Create standalone title sheet just for GEC Plan or submit rest of "C" dwgs with GEC Plan so (presumably) the title sheet for C0 is included with the GEC Plan. But make sure whatever title sheet is used or created has the correct signature blocks on it (per GEC Plan Checklist).

WWS BOOSTER 2 PUMP STATION
FINAL GRADING / EROSION CONTROL PLAN
 PROJECT NO: 70-077
 DATE: 1-10-20
 SCALE: HORIZONTAL: 1"=20' VERTICAL: 1"=20'
 DESIGNED BY: DLM
 DRAWN BY: DLM
 CHECKED BY: VAS
 SHEET 13 OF 61
C10

**WWS BOOSTER 2 PUMP STATION**

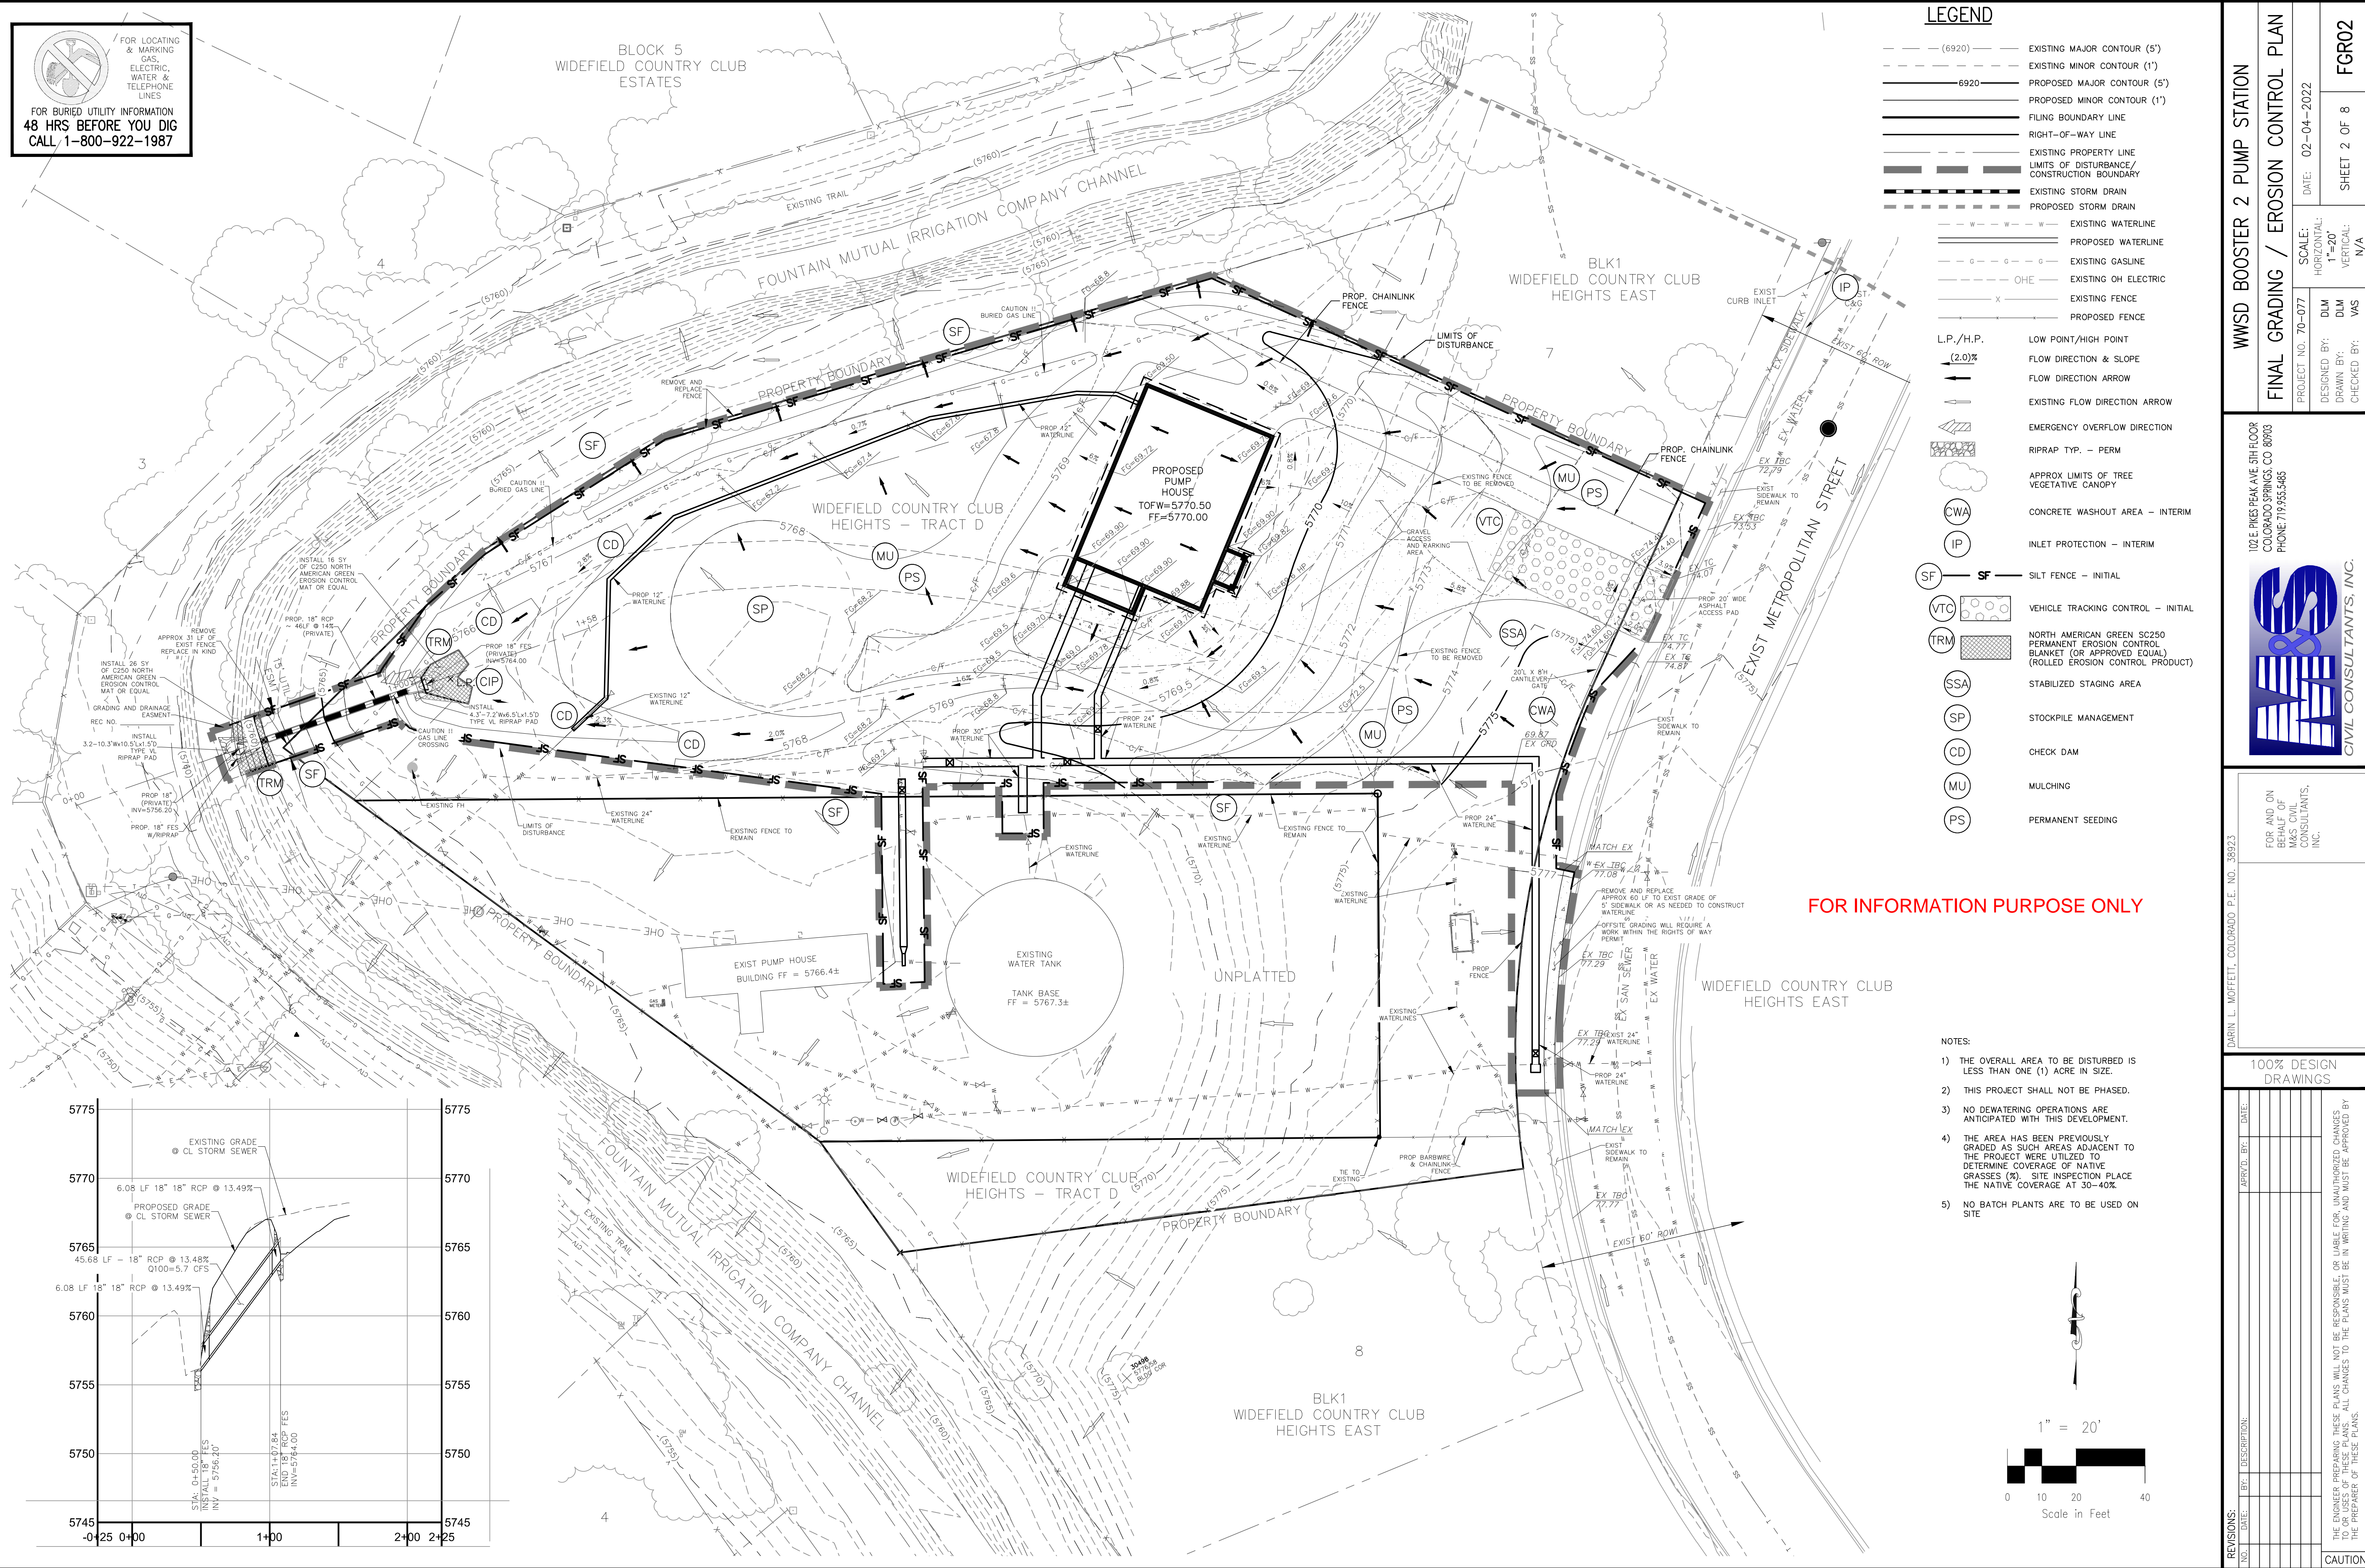
add C/F linetype to Legend

consider need for check dams within steeper section of swale.

add to Legend

show and label all drainage easements.

add to Legend

consider angling culvert more downstream so it is not perpendicular to channel, to reduce risk of causing erosion on opposite side of channel.

provide section/detail of culvert

Checklist Item "o" - callout as offsite grading and state that contractor to get an EPC "Work Within the ROW" permit.

Checklist Item "i" - add a note about condition of existing vegetation.
